3/2018/0263 19 April 2018

Proposal: Proposed conversion and extensions to the former care home to create five dwellings.

Location: 10 Knowsley Road Wilpshire BB1 9PX

drawing title: PROPOSED SITE PLAN		
scale: 1:200 @ A2		
drawn: DS	checked: PH	
date: 22/03/18		
project no: PHA/123	fig. no: 200	rev: -

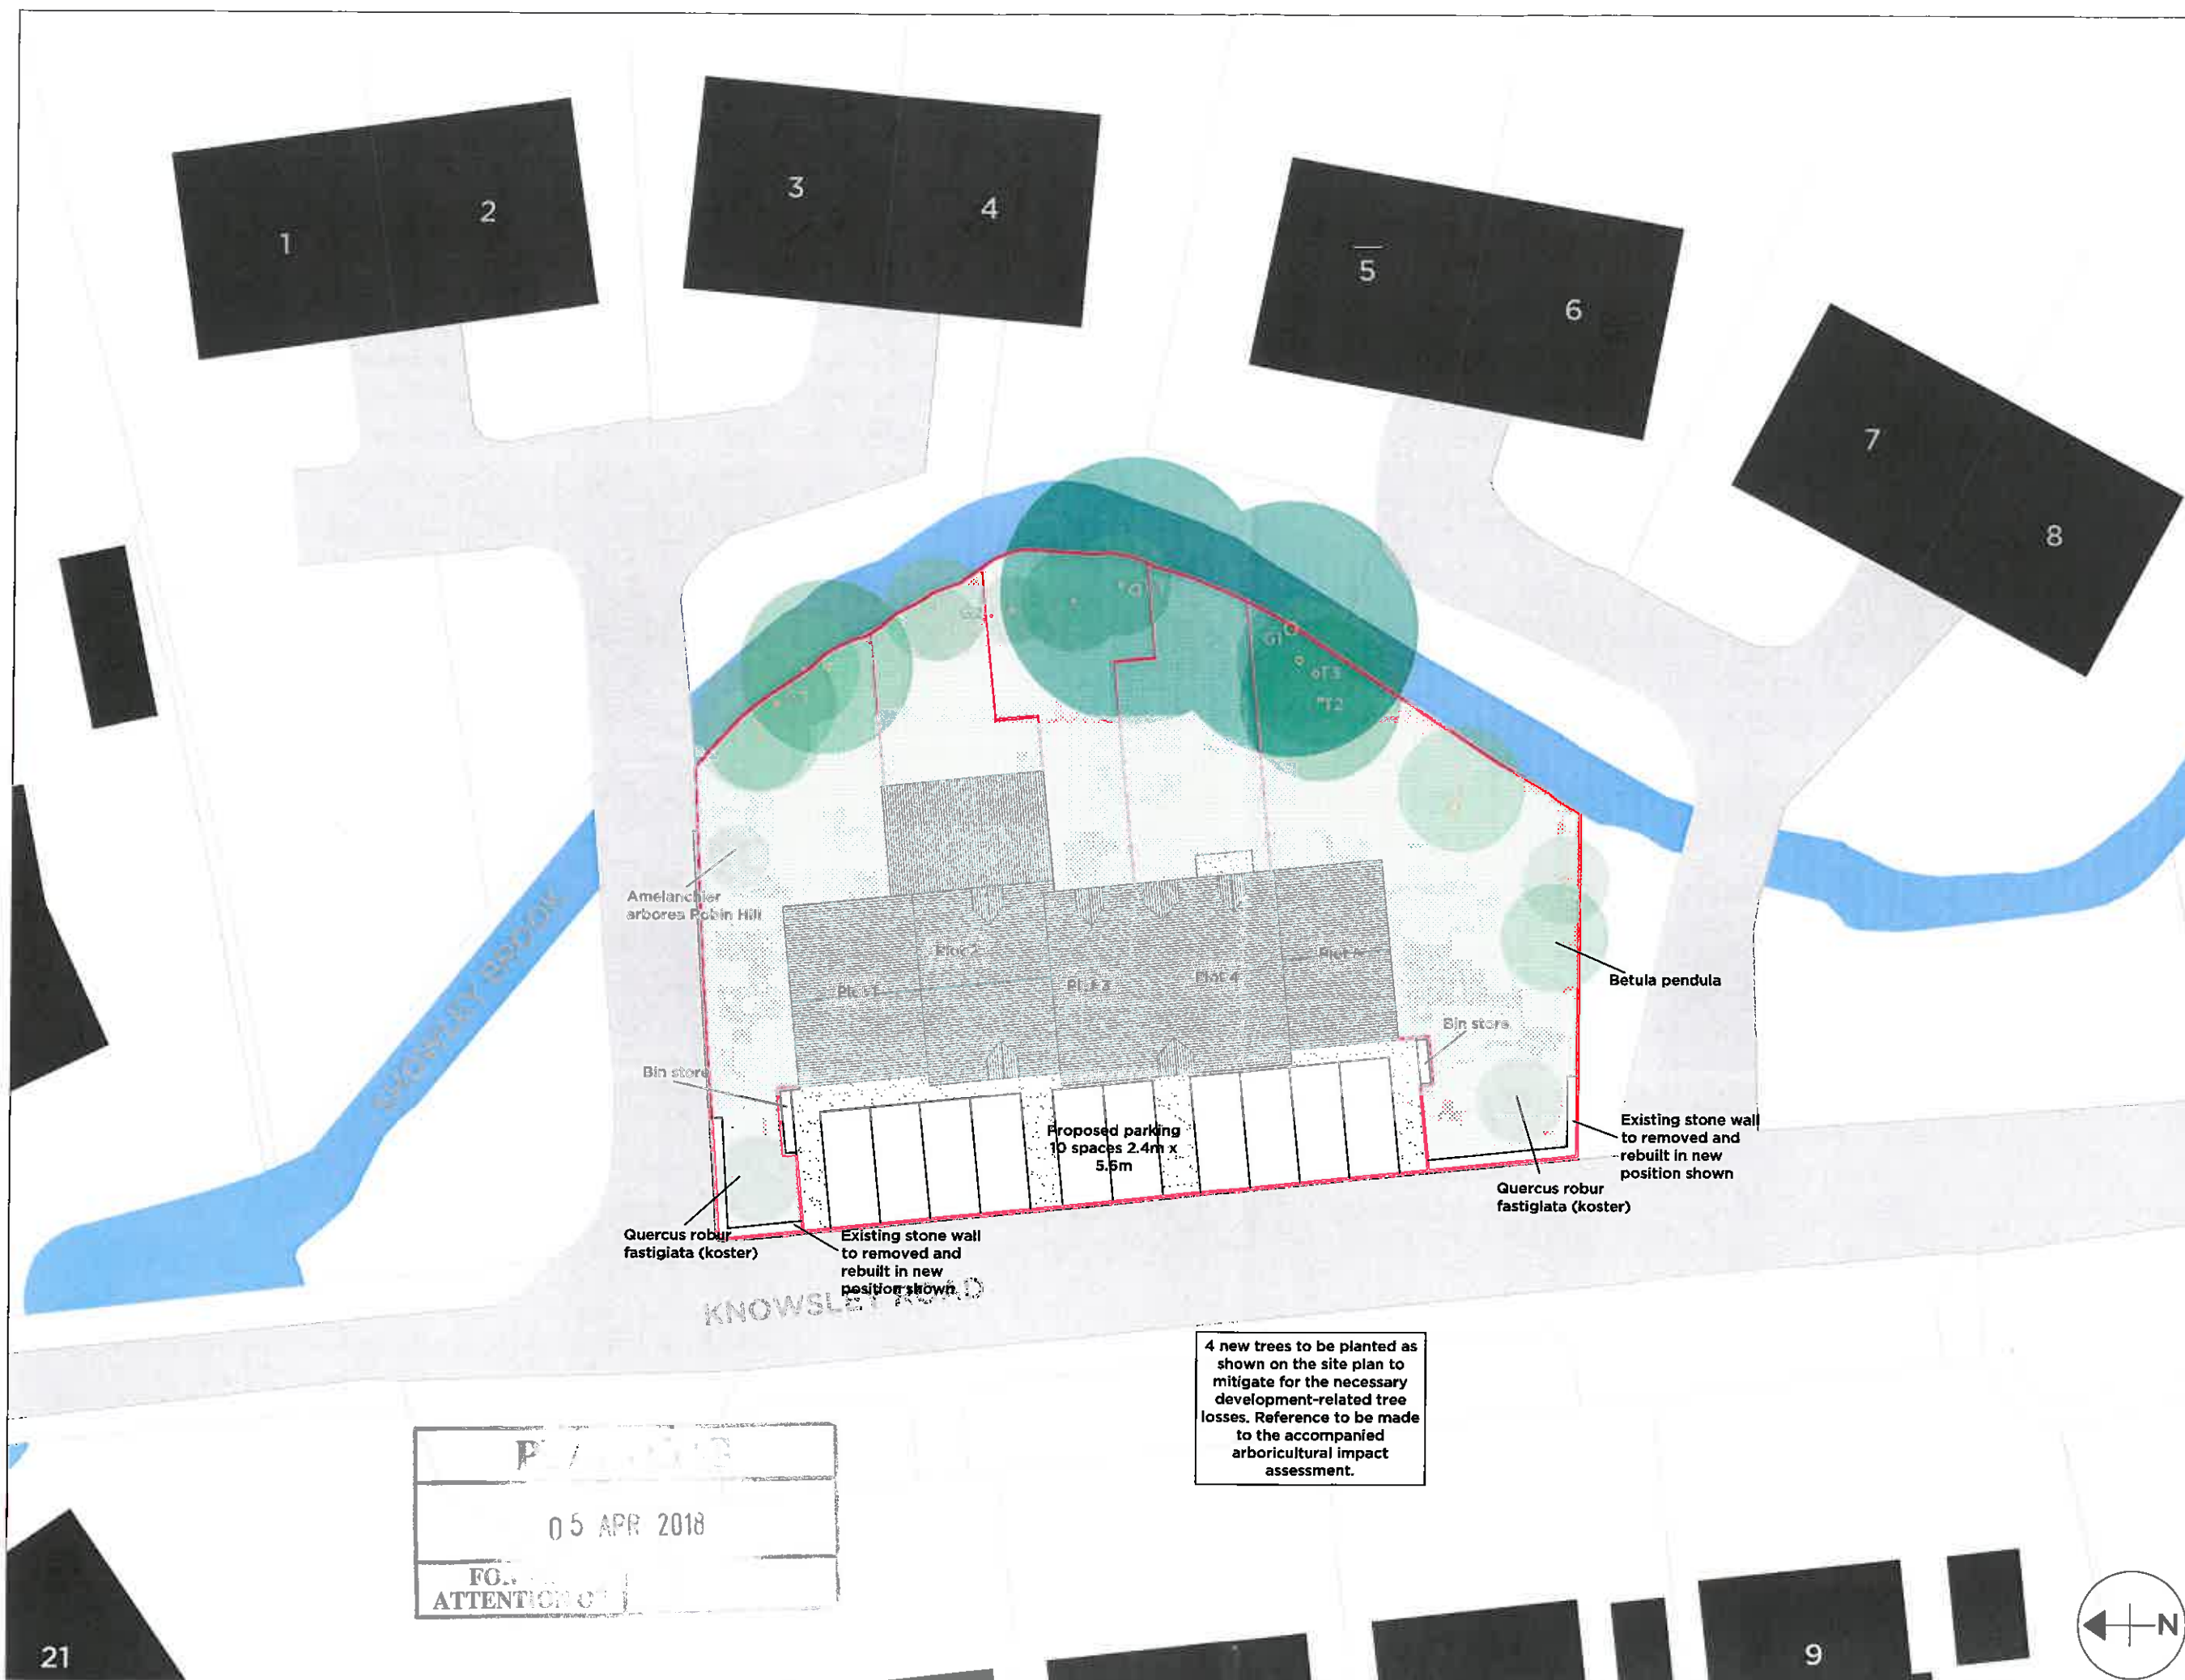
- the proposed parking bays will cause visual harm to the street scene
- result in the loss of a positive feature (the low stone wall at the front)
- create potential highway problems associated with cars egressing from them bays/site onto Knowsley Road.
- consider the extra dwellings on the site to be overdevelopment.
